Date: 7th March 2022
Our ref: CPD: 10732022
Your ref: 6/2021/3422/MAJ
Direct No: 01707 355225
E-mail: gerry.brophy@herts.pnn.police.

Re. Salisbury Square

Thank you for sight of this application on which I comment from a crime prevention perspective only. I have read the supplied documentation and I have attended the location.

CLIENT: GASCZYNE ESTATES  
 JOB: SALISBURY SQUARE HATFIELD AL9 5AD  
 DRAWING TITLE: PROPOSED SITE PLAN GROUND FLOOR LEVEL  
 SCALE: 1:250 @ A1 / 1:500 @ A3  
 DATE: NOV 2021  
 STATUS: PLANNING  
 DRAWING NUMBER: 789 - PL - 109 C  
 REV: C  
 ISSUED BY: SR

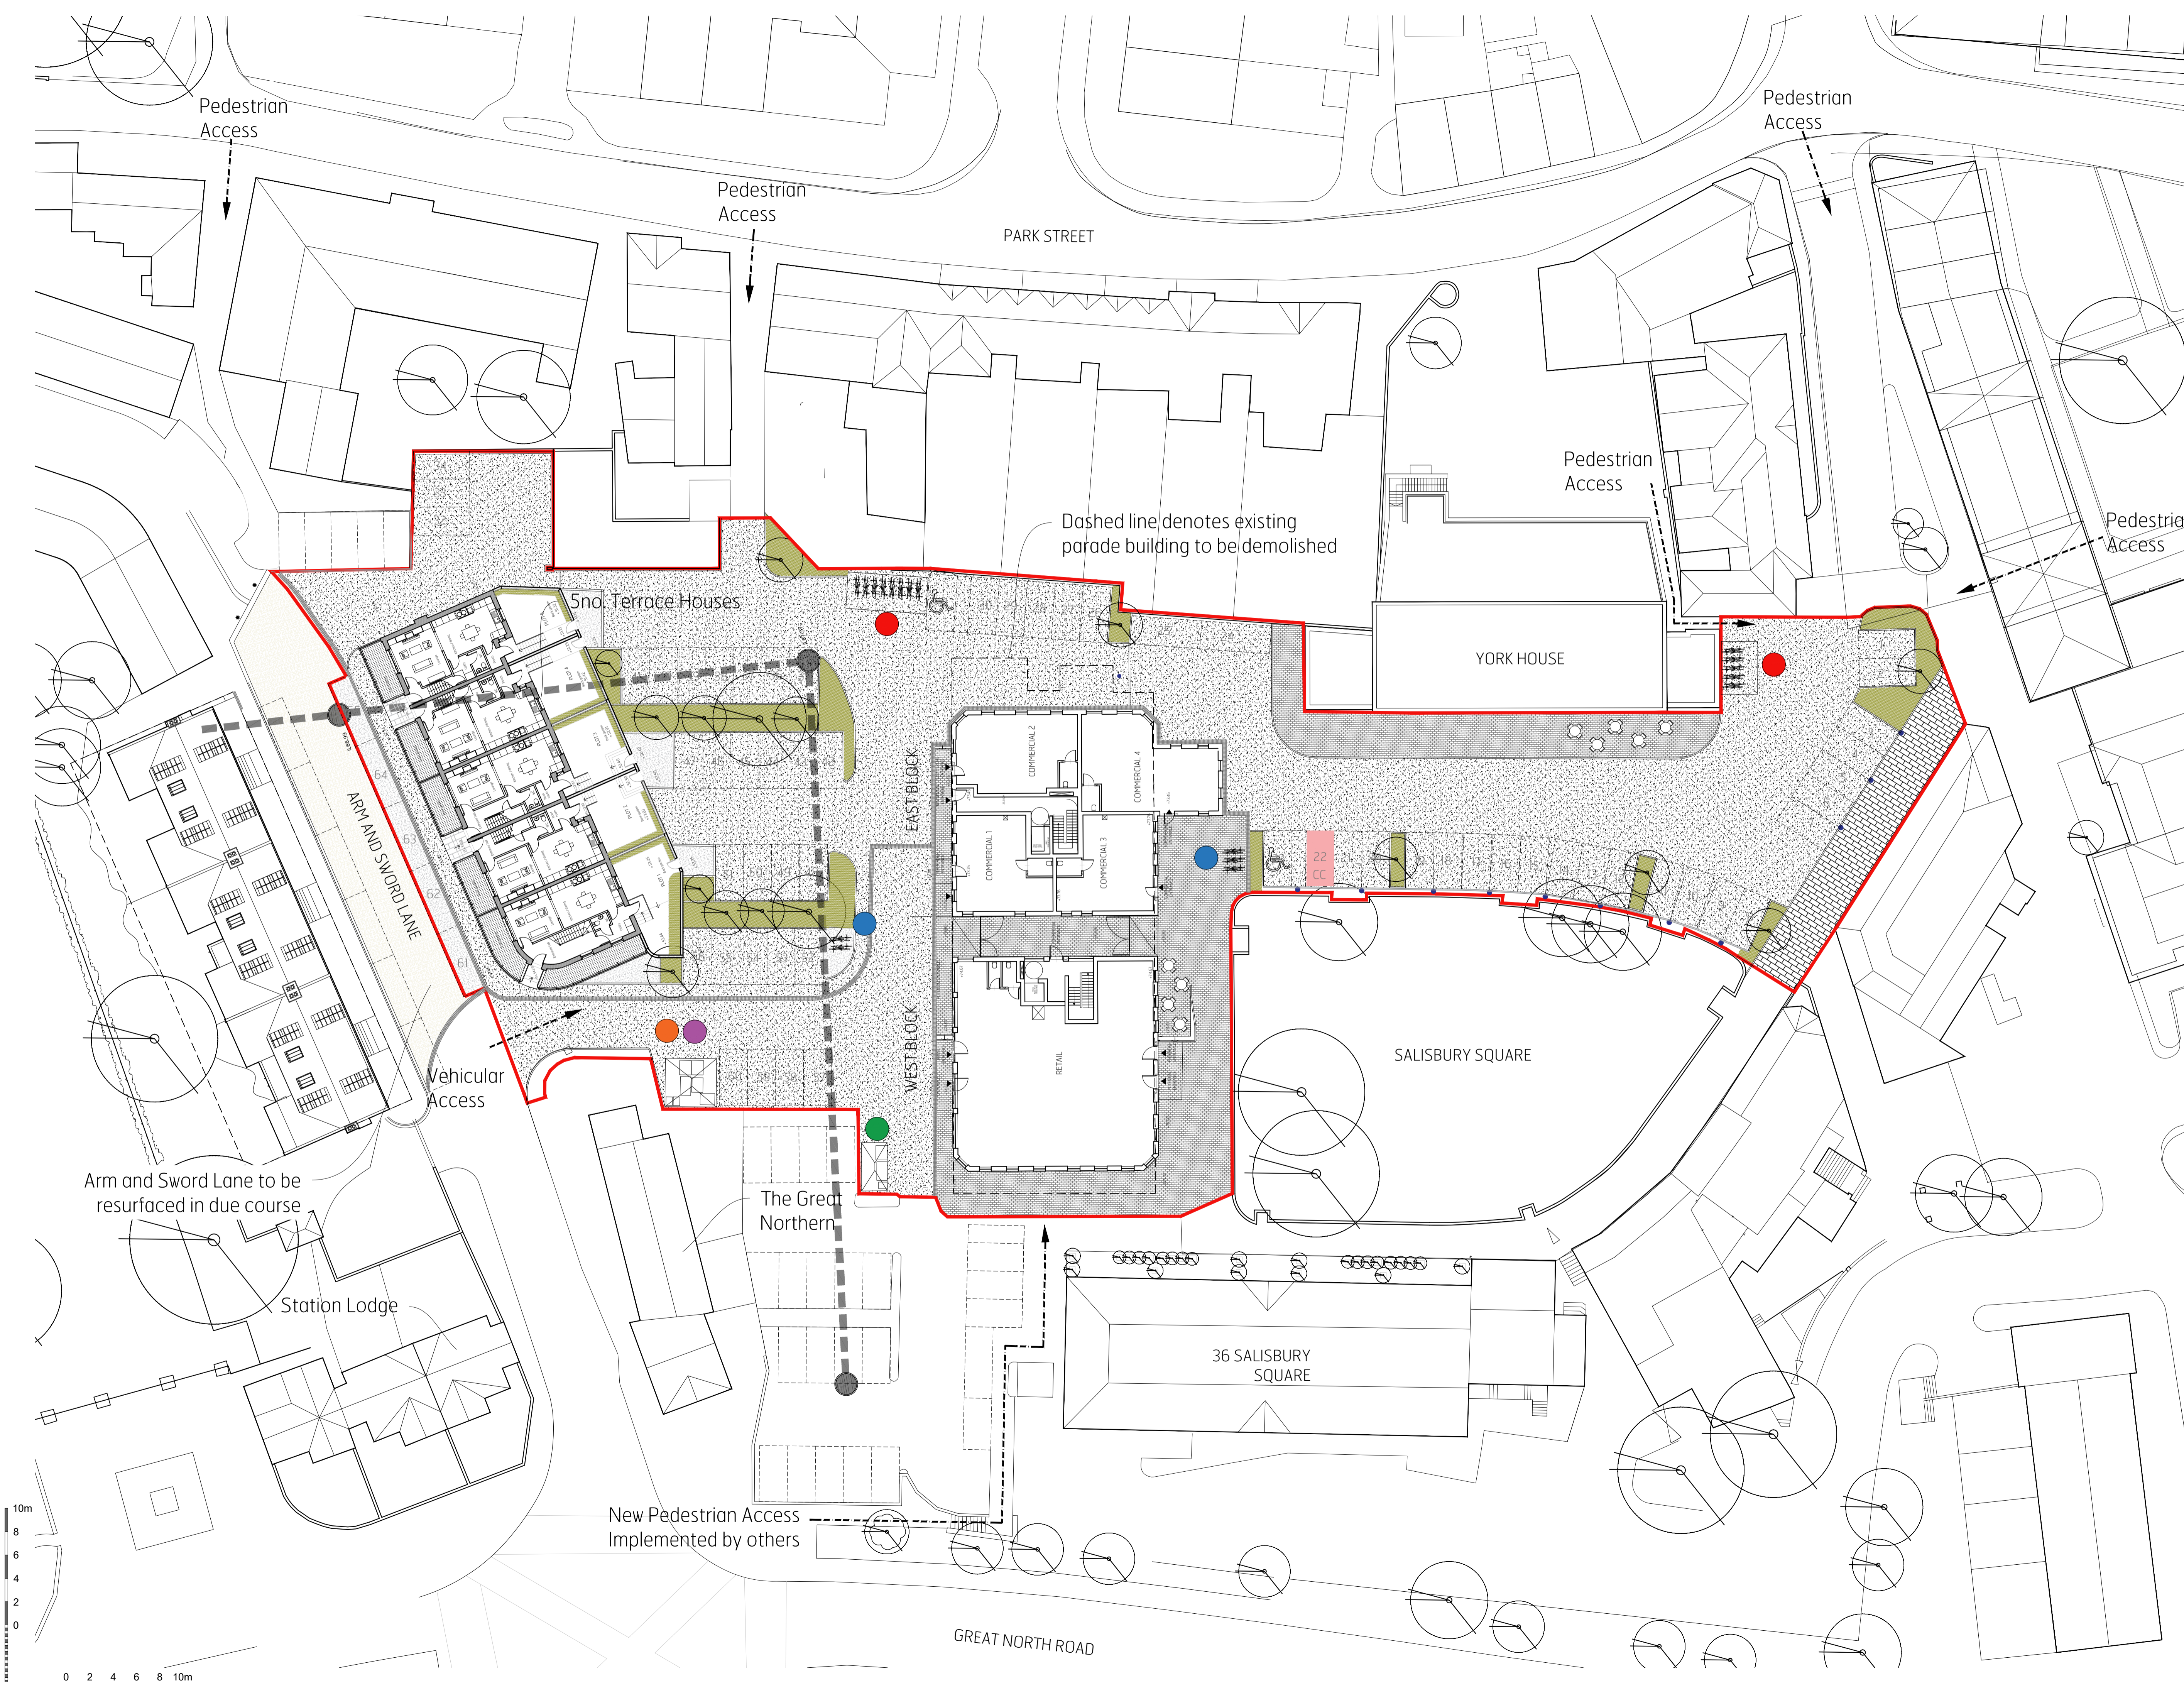
The rears of the 5 town house properties must be protected due to the exposed nature of the area. No's 64 and 65 particularly so as they are within a communal area on the corner of the block. Stout key lockable gates must be fitted.

I would expect to see some low lux level lighting to the front of the building to allow users to both see and be seen.

Likewise, the widely dispersed car parking areas will need some low-level illumination from wall or column mounted luminaires (not bollards).
